From: Tim Screen
Sent: 12 January 2023 13:48
To: Linda Griffiths
Subject: FW: 22/01715/OUT Land East of Park View, Woodstock - Landscape Response

Having reviewed the landscape and visual implications, and as addressed under my correspondence with Gemma Pengelly of Terence O'Rourke, I wish to confirm my acceptance of the negotiated outcome and the overall LVIA results.

## Open space standards

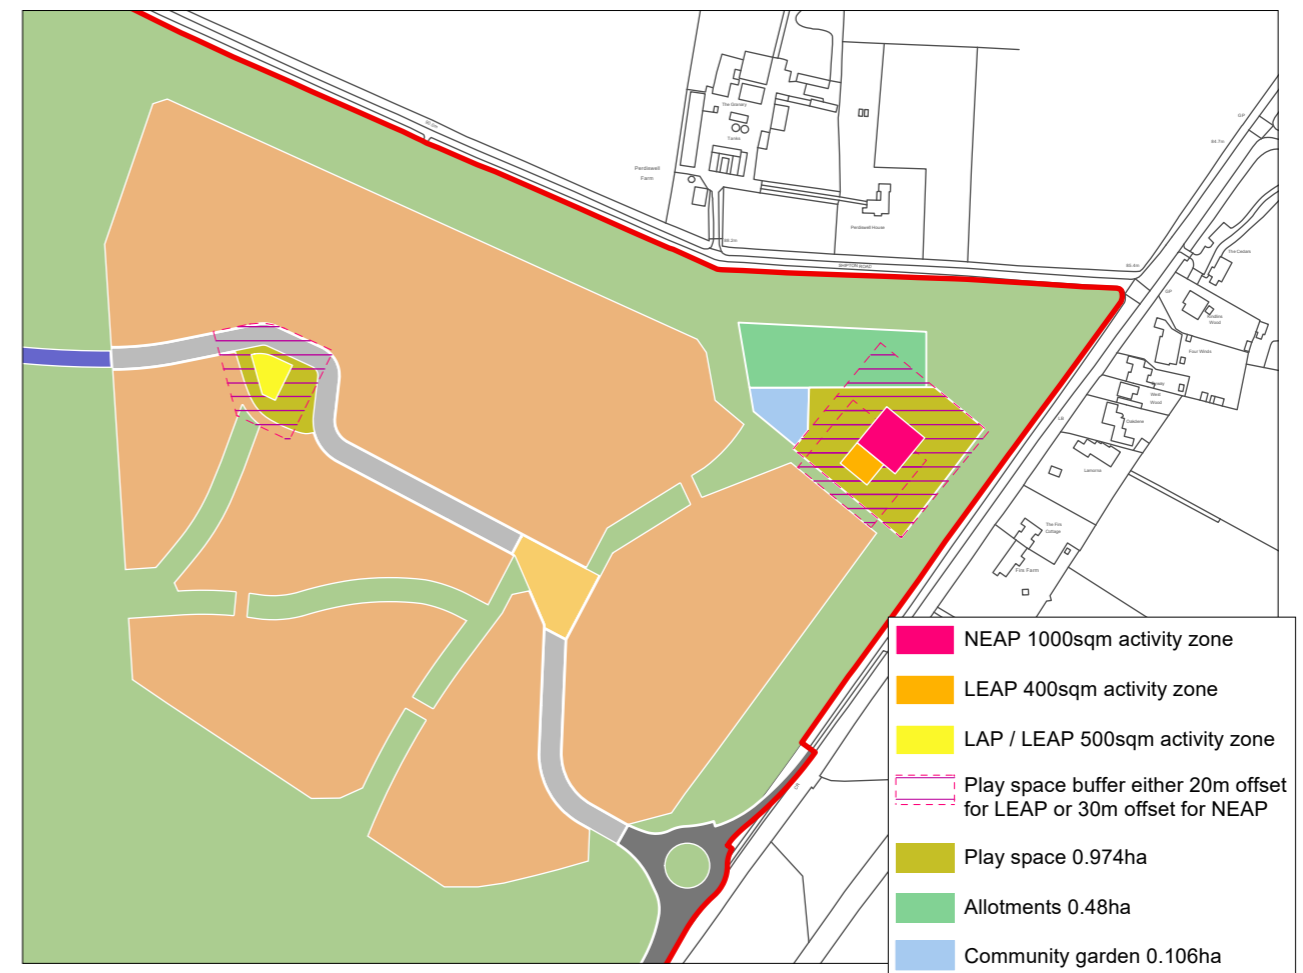
It is difficult to measure off the 1:4000 A3 Parameter Plan to ascertain whether the area meets with CDC policy. The minimum requirement is 0.46 ha, calculated thus:

Total no. 1,245 people (2.49 average household x 500 homes) @ 0.46 ha of allotment space required $((0.37 \times 1,245) / 1000)$.
